Subject: 1400023256 - Unit 800, Bretton Park Industrial Estate, Bretton Park Way, Savile Town, Dewsbury, WF12 9BS - 2025/91202

Planning Application Ref:-	2025/91202
Northern Gas Objection Reference:-	1400023256
Location:-	Unit 800 Bretton Park industrial Estate, Bretton Park Way,
Savile Town, Dewsbury, WF12 9BS	
Proposal:-	Erection of three storey office extension, alteration of hard surfaced area to car park, with associated works including landscaping.

Dewsbury – Crossgates 450 ST 17 Bar MOP,

PROPOSED SITE PLAN

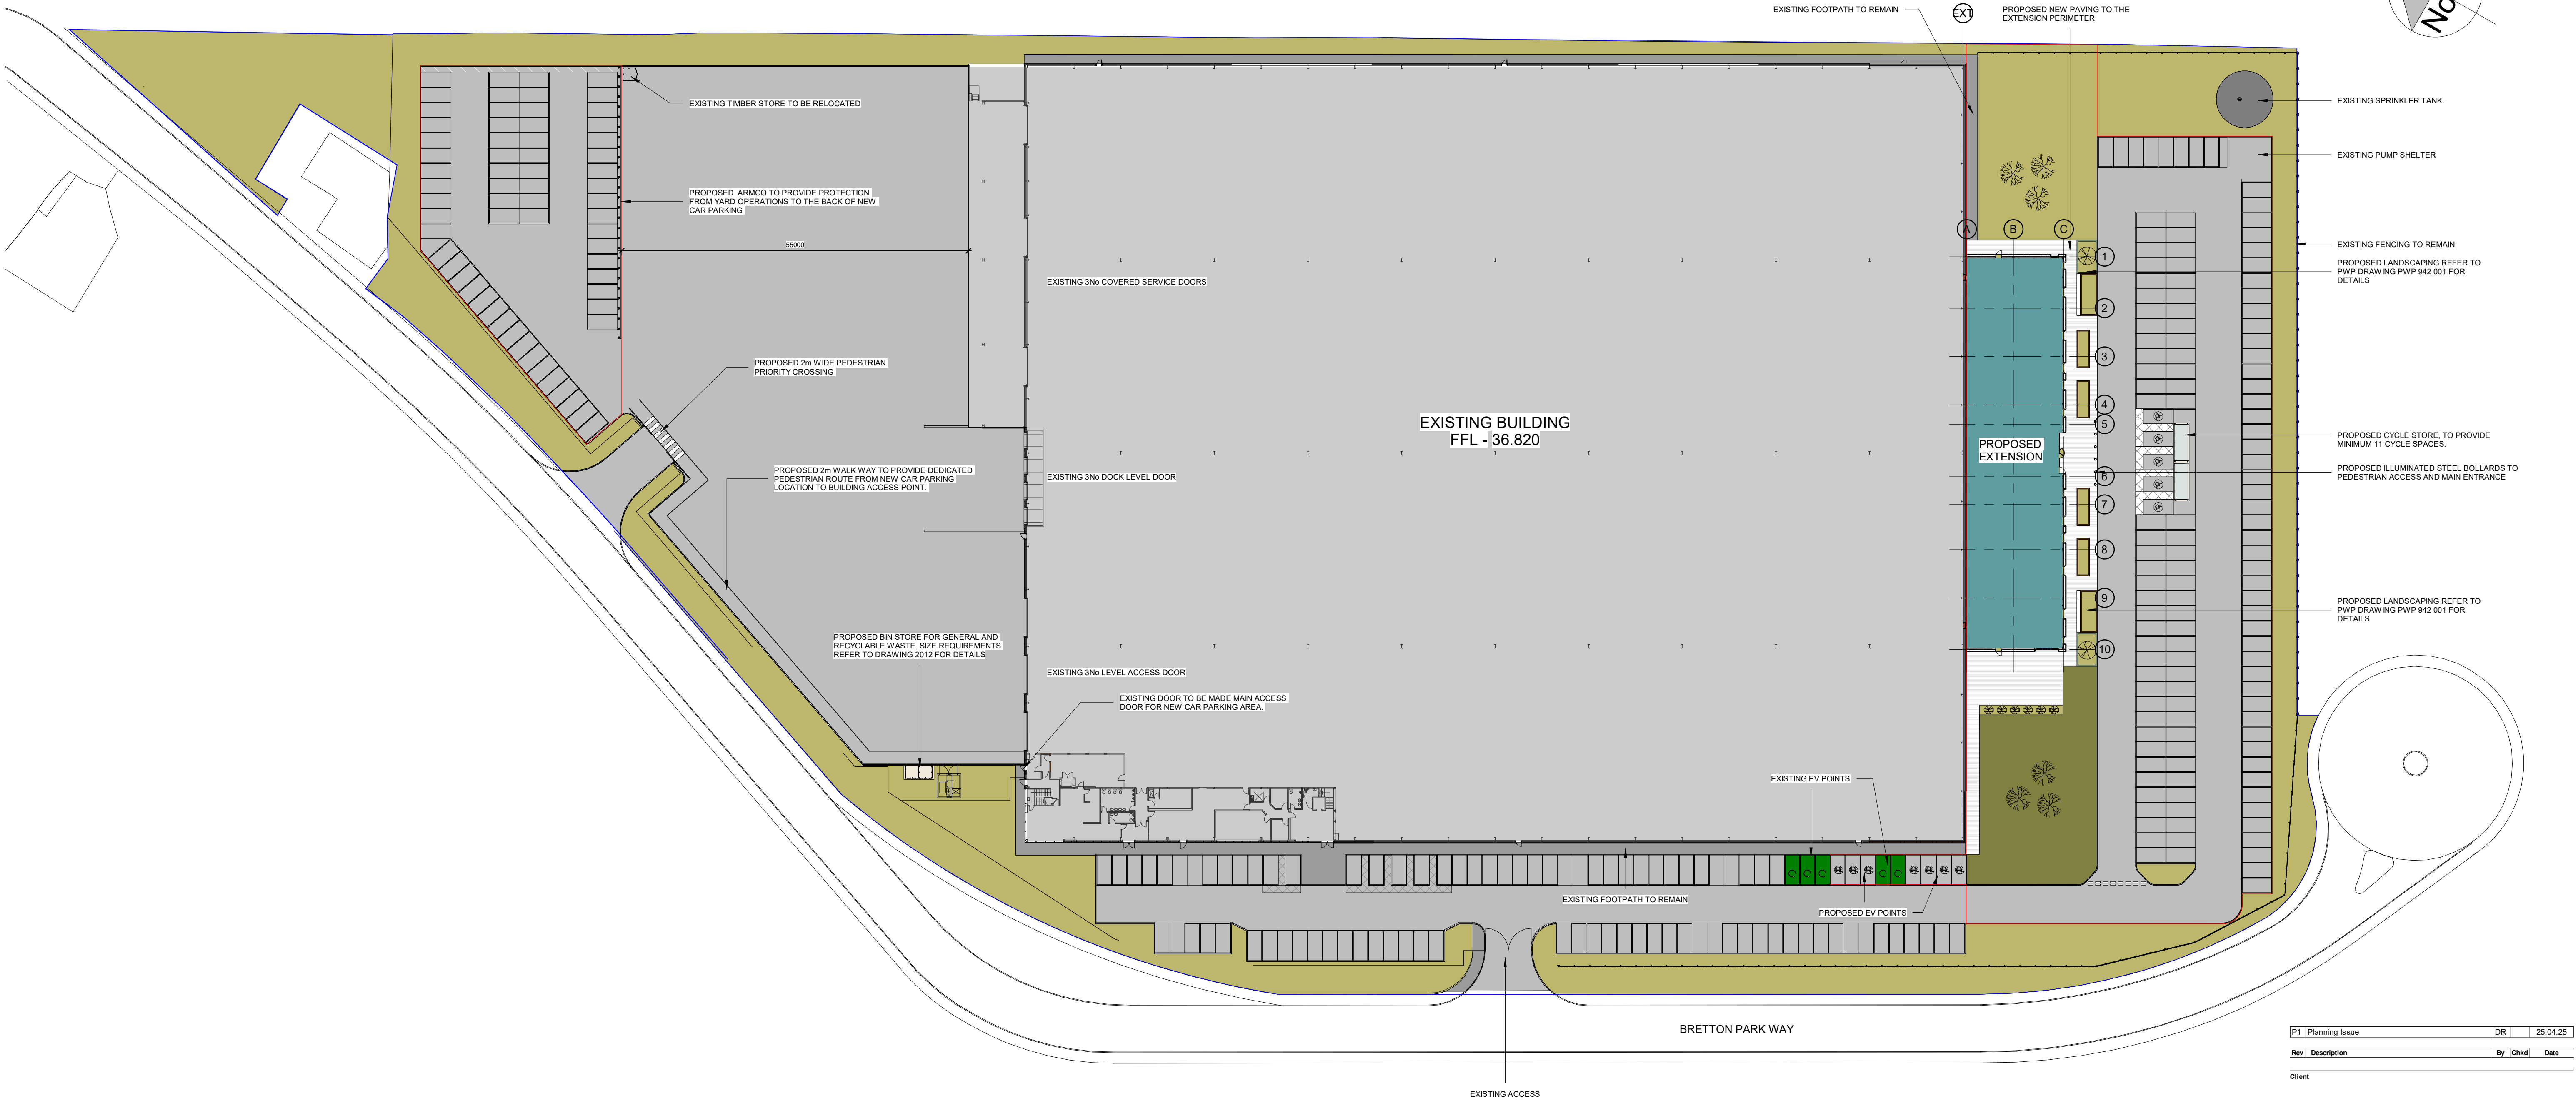
1. There is one Northern Gas Networks High Pressure Gas Pipeline that is running through the gardens of the proposed properties;

There is one existing Northern Gas Networks High Pressure Gas Transmission Pipeline which passes through the rear gardens of the development area(s), as follows:

“ **Dewsbury – Crossgates** ” which is 450 mm dia. (18”) and operates at 17 bar MOP (Max Operating Pressure) (equivalent to 247 Pounds / Inch²).

For this particular asset, our safety advice is based on industry standard (IGEM TD1 Ed. 6), which states that there should be no “Occupied Buildings”, within **7 metres** of the pipeline, in other words a strip **14 metres** (42 feet)

wide centred on the pipeline should be clear of buildings. (This is known as the Building Proximity Distance: BPD)

Regardless of item 1 above, NGN would not agree to any buildings being placed within the easement.

In general: It is unacceptable for any building to be constructed directly over a High Pressure gas Transmission pipeline.

1. There will be no **NEW** occupied **buildings or extensions** within **7 metres** of the pipeline.
2. There will be no **groundworks** within 10 metres of the pipeline.
